**KIRKLEES METROPOLITAN COUNCIL
INVESTMENT & REGENERATION SERVICE**

**DELEGATED DECISION TO DETERMINE APPLICATIONS FOR
NON-MATERIAL AMENDMENTS**

Reference No: **2023/NM/90743/E**

Description: Non material amendment to previous permission
2019/91657 for erection of 30 dwellings

HOUSE TYPE B
1902-HT-B-01B
STATION ROAD, SKELMANTHORPE
YORKSHIRE COUNTRY PROPERTIES
SCALE:1:100@A3 - MAY 2019
PARKER PEEL
ARCHITECTURAL
e jp@parkerpeel.co.uk w www.parkerpeel.co.uk t01924 921 860

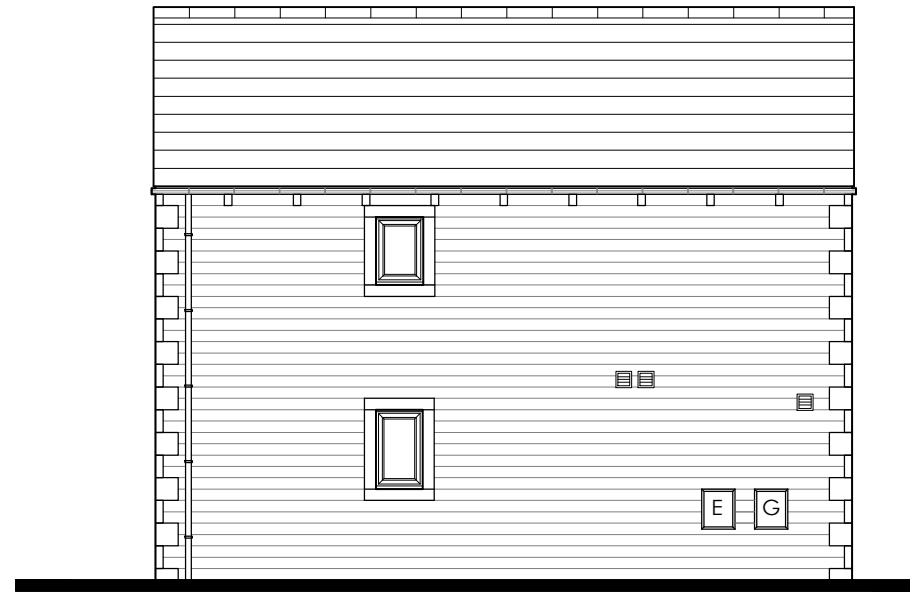
- B Type (Plot 13-15) Side lights removed from French doors on rear elevation.
- C1 Type (Plot 12) Additional side window added to bedroom 2.
- C2 Type (Plot 8) Window added to Plot 8 bathroom only.
- G Type (Plot 29) Single story rear extension added to provide additional kitchen space and utility room added.
- J type (Plot 30) Rear window removed from bedroom 2.
- K Type (Plot 25) Minor adjustments to overall build to suit construction purposes.
- L Type (Plot 24) Parapet walls introduced at roof level.
- M Type (Plot 23) Room above garage removed, other amendments including repositioned windows.
- N Type (Plot 26) Side door to utility added and double window to the dining room replaced with a triple window.

HOUSE TYPE C1
1902-HT-C1-01B
STATION ROAD, SKELMANTHORPE
YORKSHIRE COUNTRY PROPERTIES
SCALE:1:100@A3 - MAY 2019

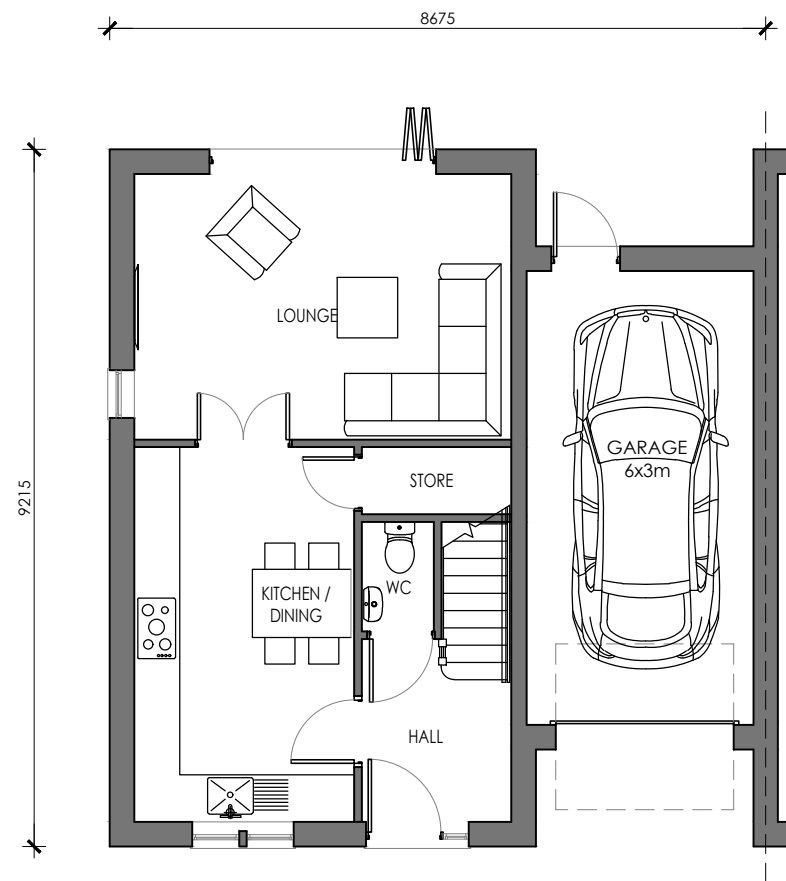
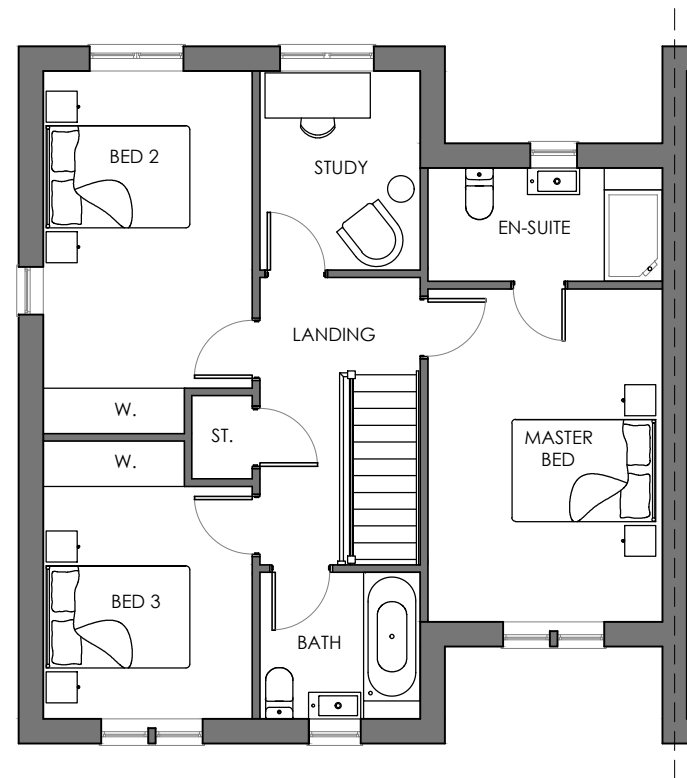
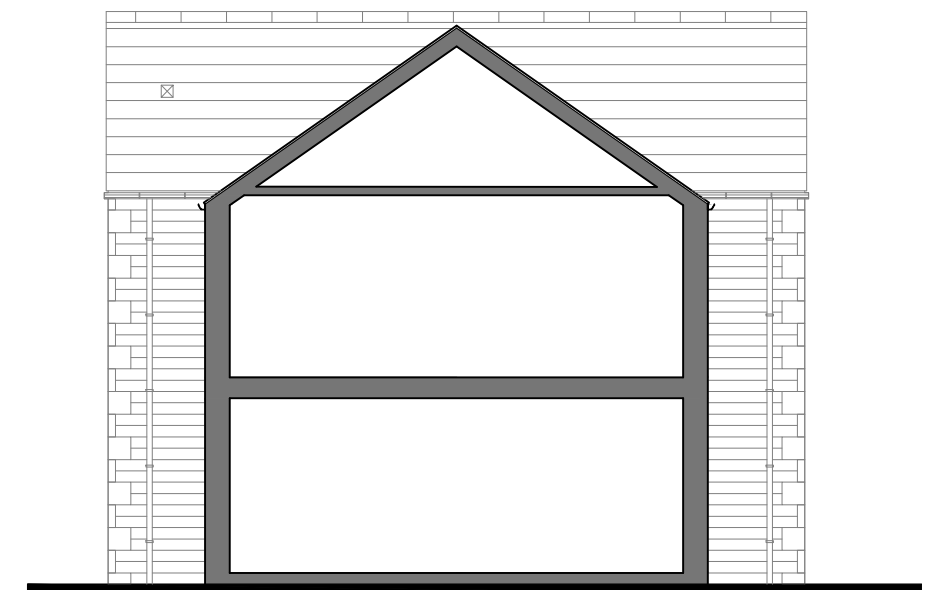
- C1 (plot 12) ground floor side window moved.
- G (plot 29) changes to footprint dimensions (8383mm x 6860mm previously approved, 8495mm x 6852mm now proposed).
- The relief in G's front and rear elevations also appears to have been deleted (resulting in dwelling having a single roofline), although this isn't reflected in the Site Layout Plan (rev K).
- L (plot 24) front ground floor projections slightly reduced in size.
- Unit 23 moved slightly southwestwards towards site boundary.
- Unit 24's garage moved slightly southeastwards towards trees.

HOUSE TYPE L
1902-HT-L-02C
STATION ROAD, SKELMANTHORPE
YORKSHIRE COUNTRY PROPERTIES
SCALE:1:100@A3 - MAY 2019

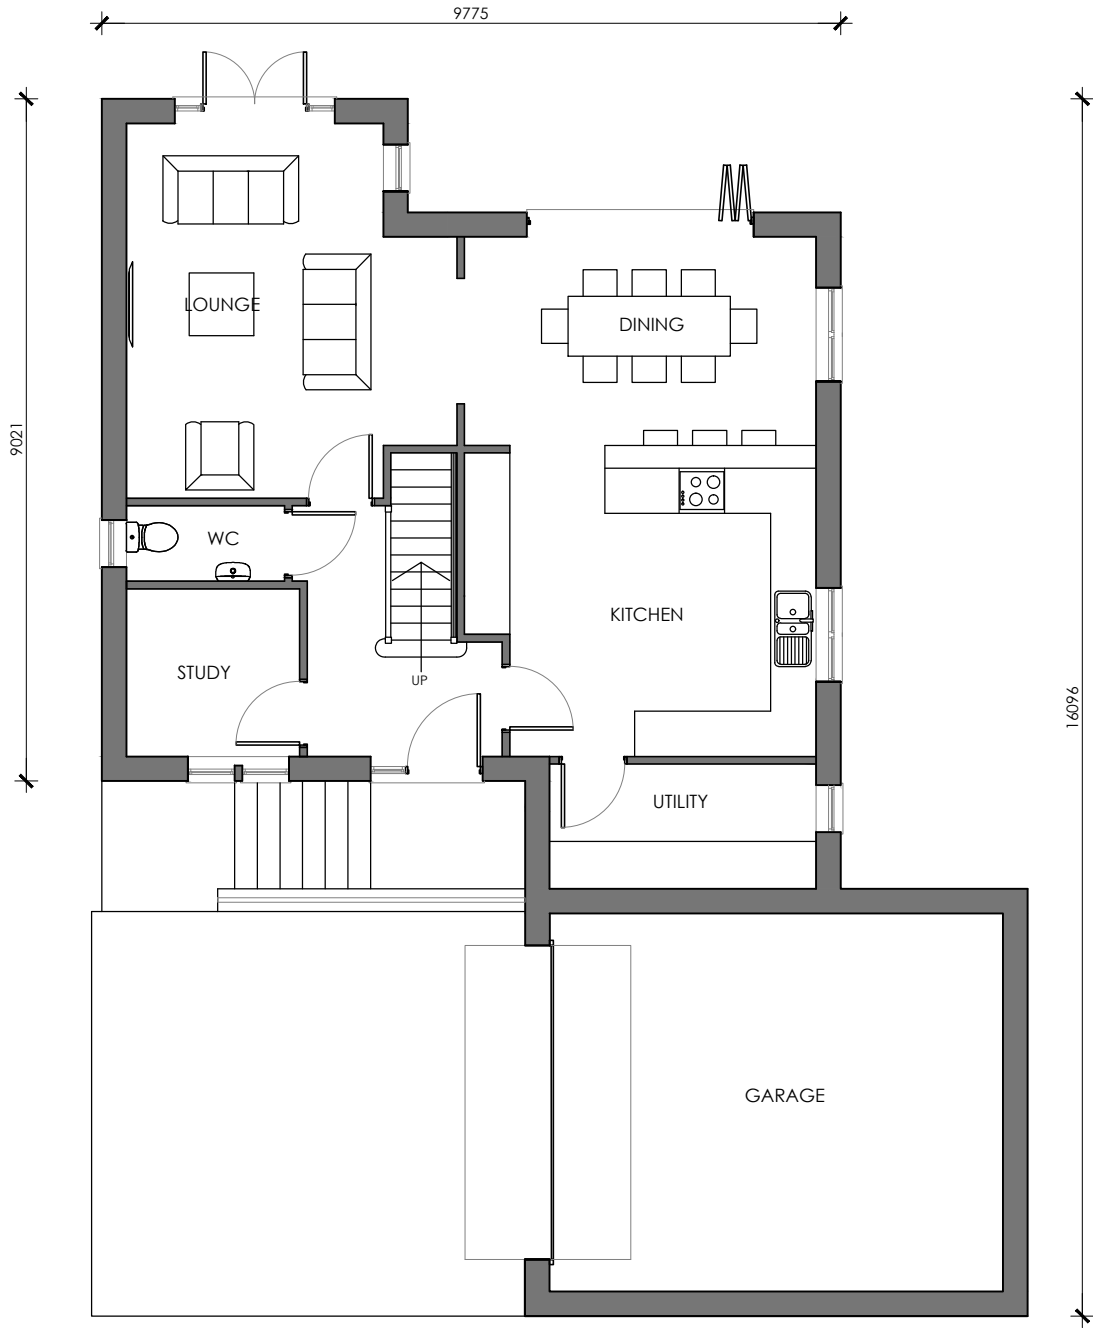
Although the applicant has stated that parapet walls would be introduced at roof level to the L Type unit (plot 24), these features were already illustrated and approved under the previous permission 2019/91657.
